From: Dunderdale, Chris <Chris.Dunderdale@lancashire.gov.uk>
Sent: 21 December 2018 07:42
To: planning
Subject: RE: 3/2018/0786 Dog and Partridge

Thank you for re-consulting the Lead Local Flood Authority (LLFA) on the above application. I have reviewed the information provided and I have the following comments to make:

The application is for the conversion of an existing restaurant (A3) to create twelve apartments (C3) and the siting of four holiday lets.

# PROPOSED BLOCK PLAN

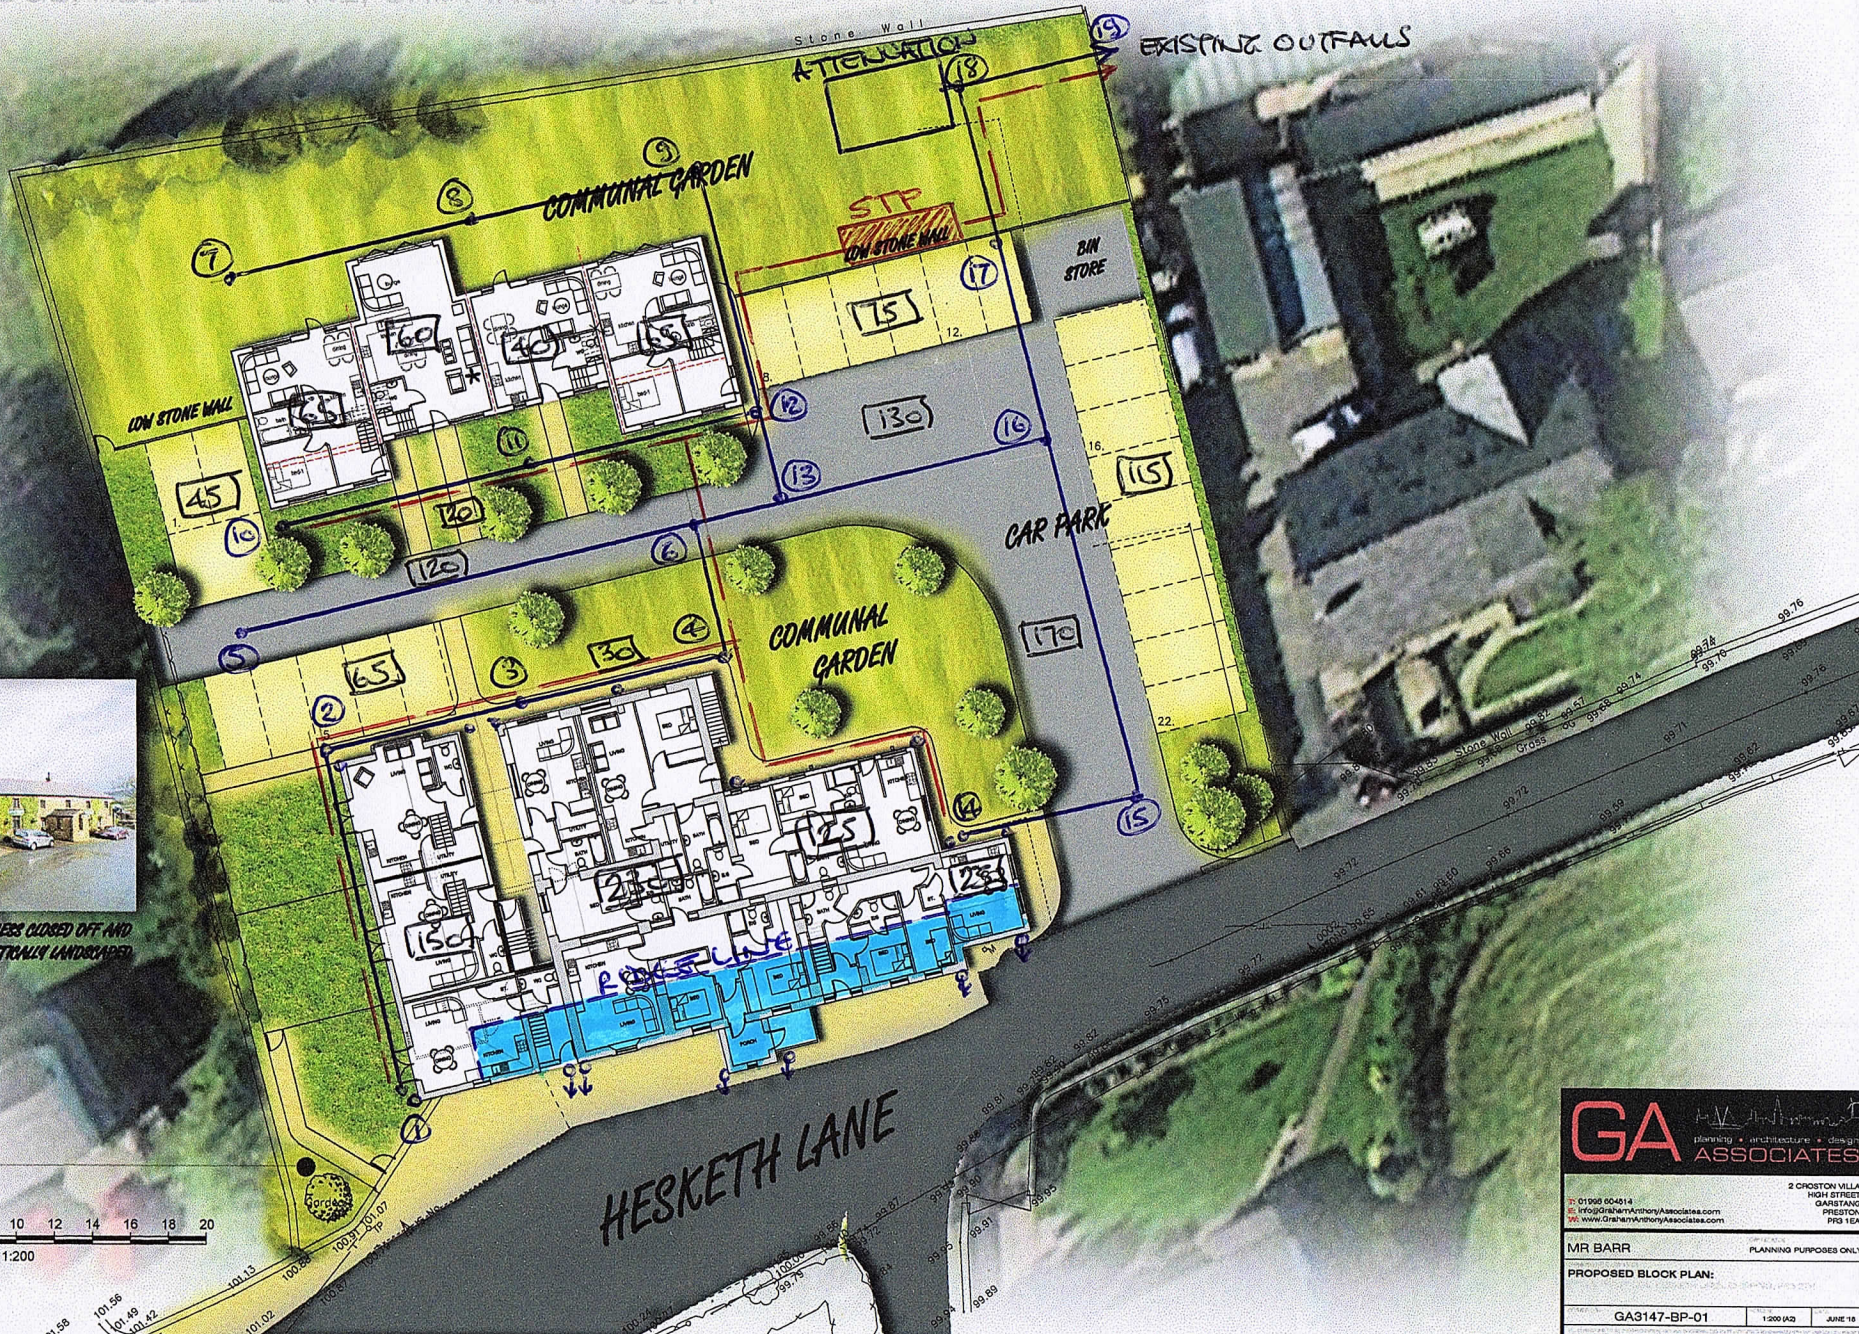
- c) The preliminary surface water drainage layout plan (appendix B of the drainage strategy report) appears to show surface water from a small area of the site being drained to ground (i.e. the plots adjacent to Hesketh Lane). This arrangement conflicts with the conclusions of the applicant's drainage strategy report, which suggest that infiltration will not be possible due to existing ground conditions. This will need to be brought to the attention of the applicant so that further clarification can be provided in this regard. Should the applicant intend to proceed with the use of soakaways for part of the site drainage, then they will first need to demonstrate that they have worked through an appropriate assessment carried out under Building Research Establishment (BRE) Digest 365 revised 2016. This is to confirm the suitability of soakaways within the development site. If soakaways are shown to be unsuitable, then the applicant will need to provide an alternative method for draining this area of the site.
